Current Zoning: MUDD-O (Mixed-Use Development District-Optional)
Proposed Zoning: MUDD-O SPA (Mixed-Use Development District-Optional, Site Plan Amendment)

Approximately 20.44 acres located in three development areas. Development Area A includes 16.01 acres and is located south of Yorkmont Road and west of Price Lane. Development Areas B and C total 4.43 acres and are located north of Tyvola Road and south of National Avenue.

The petition proposes to amend a portion of the previously approved City Park rezoning to allow up to 220 residential dwelling units, 450 hotel rooms, 135,000 square feet of retail, and 100,000 square feet of self-storage warehouse.

Staff recommends approval of this petition upon resolution of outstanding issues related to transportation.

RZ1.1

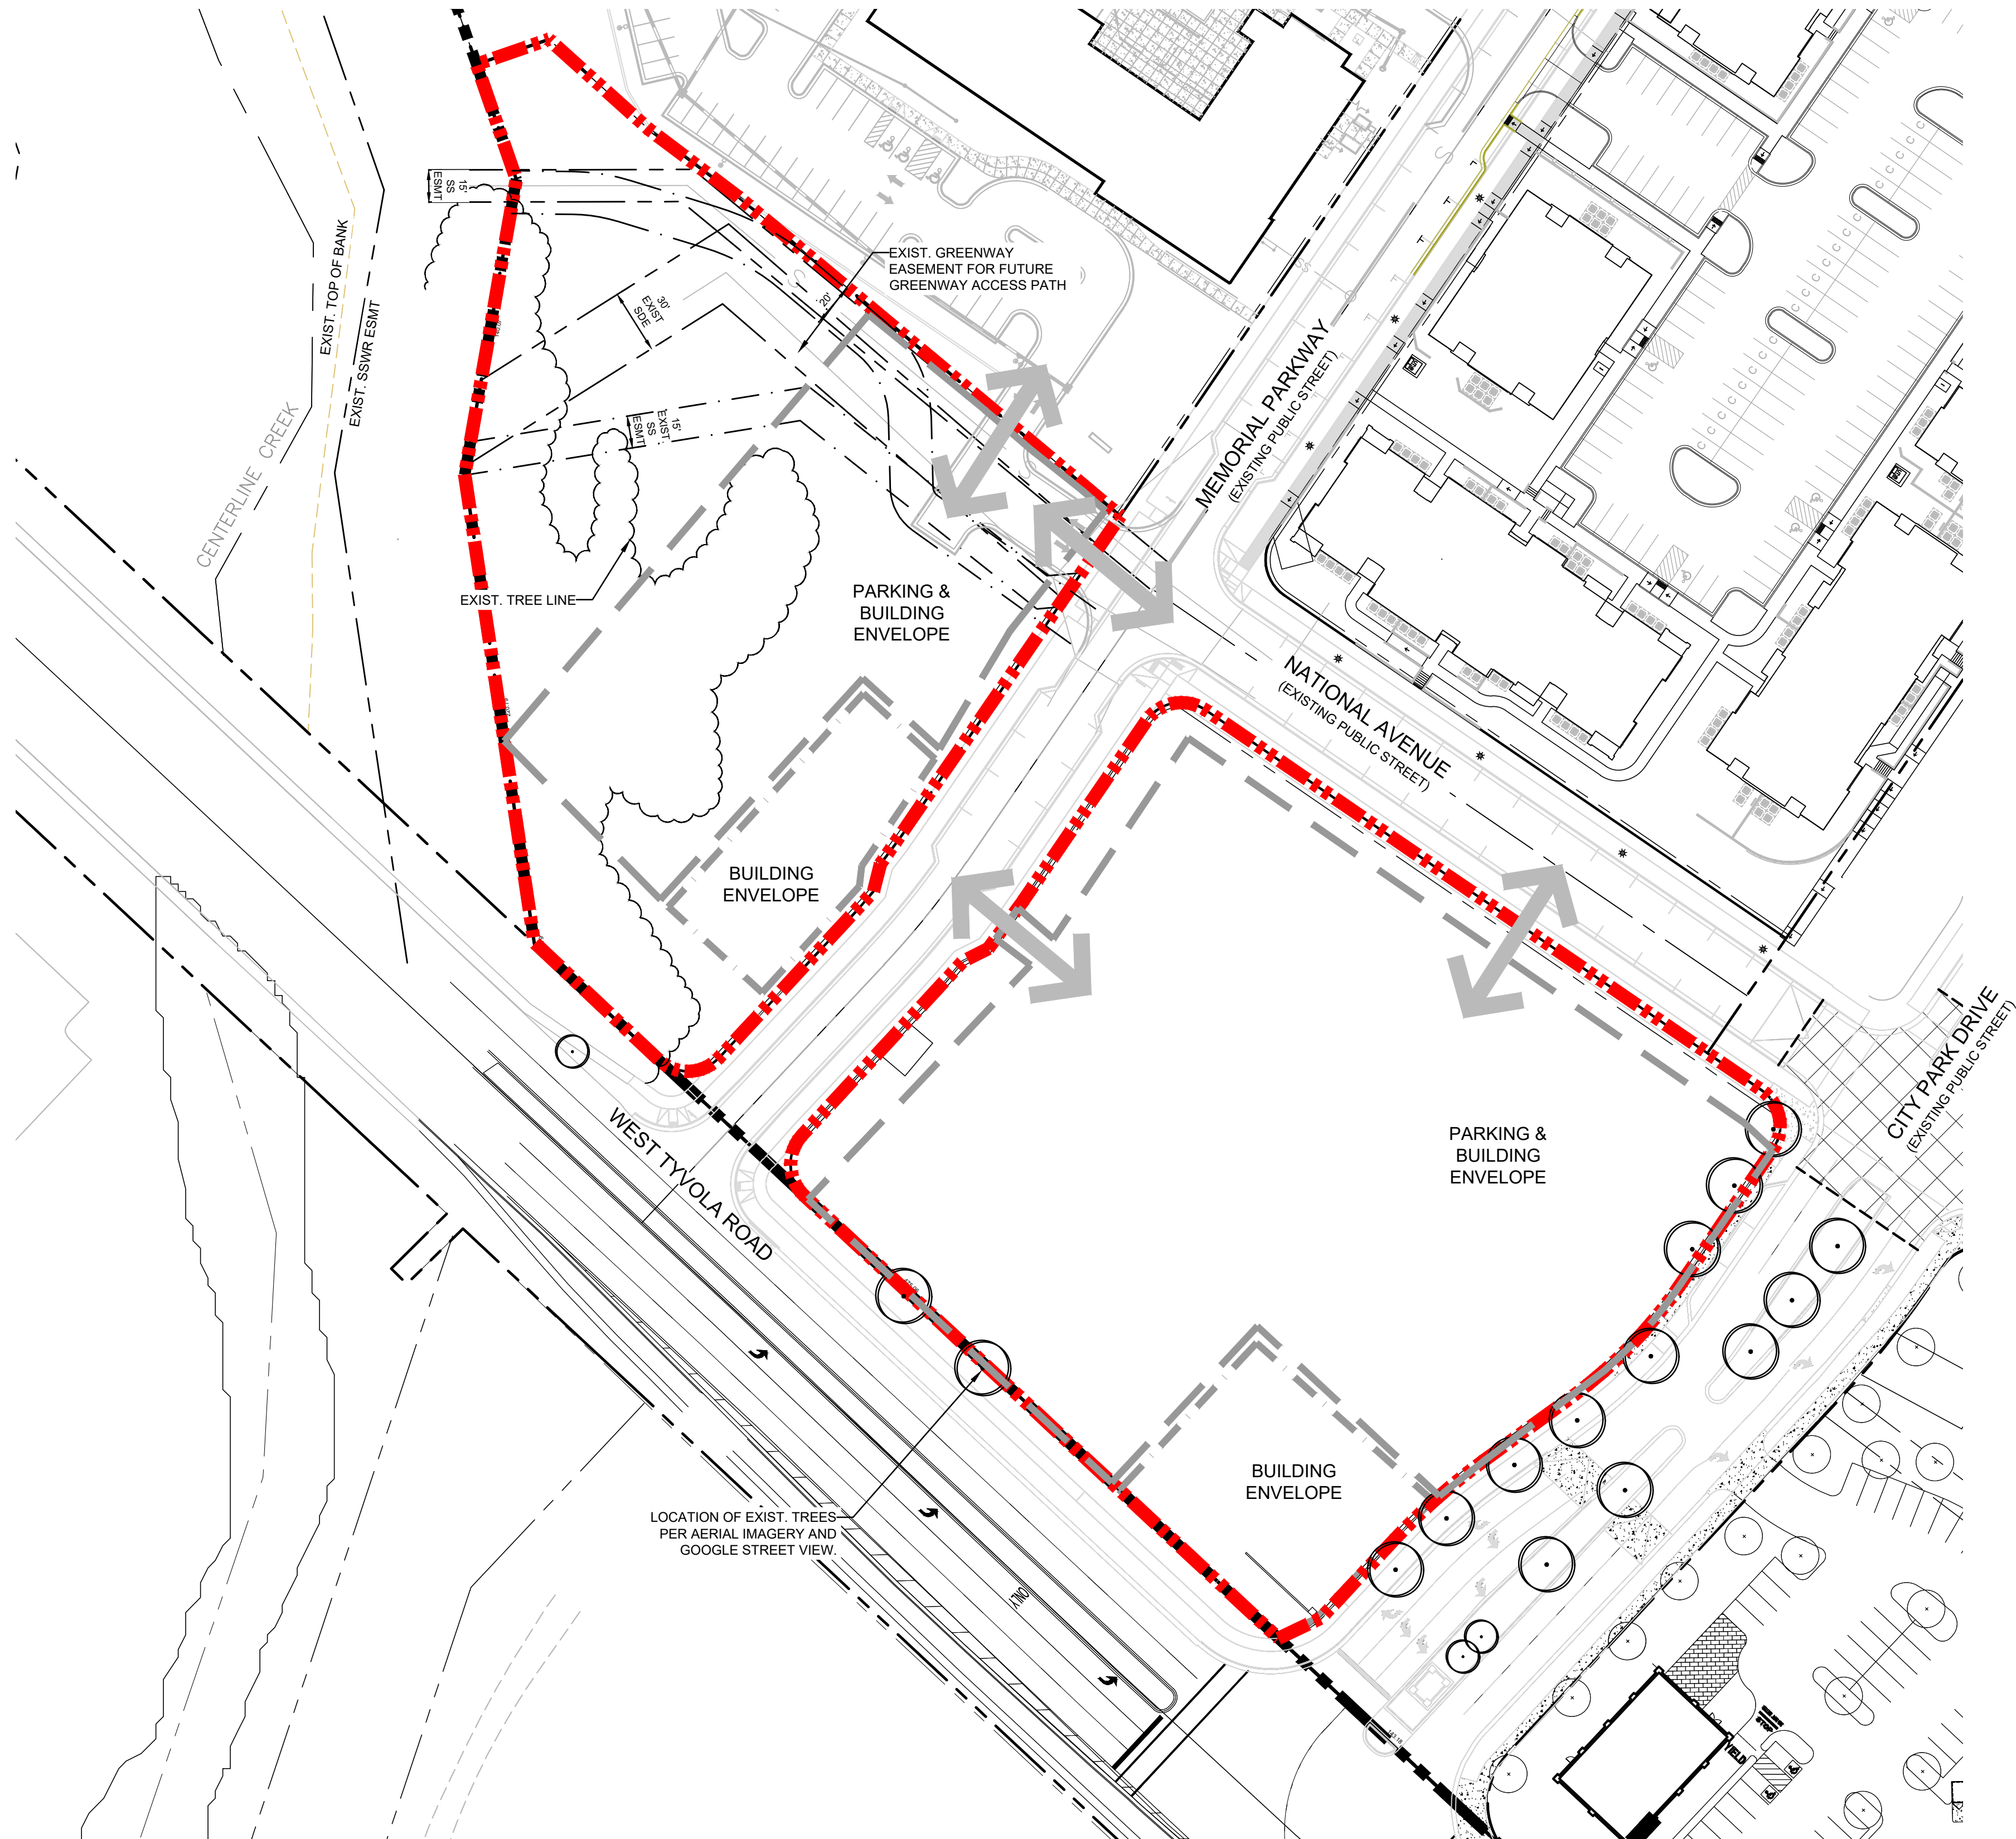
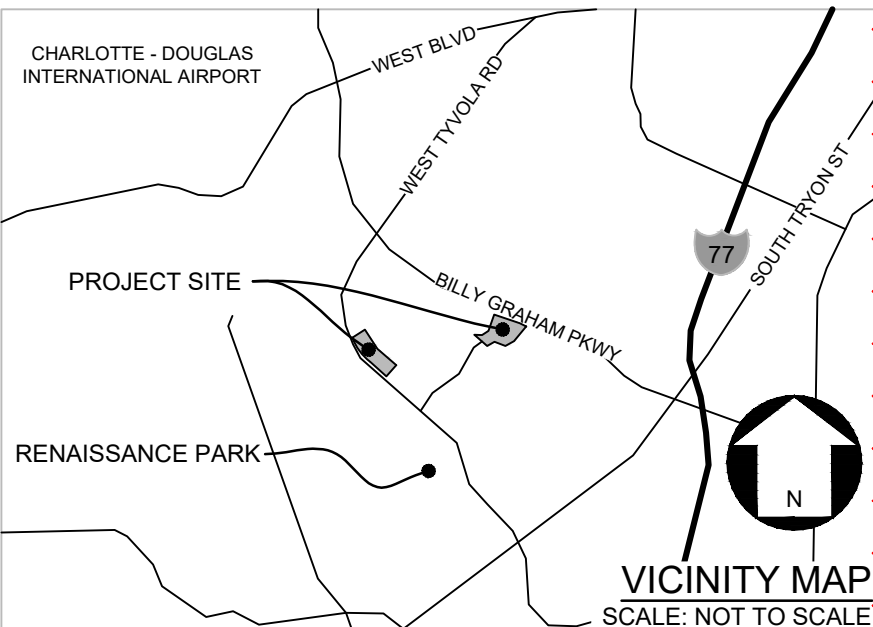
1. Provide a revised TIS addressing all outstanding issues.
2. Provide a revised conditional note for the traffic signal at Speer Boulevard and Tyvola Road.
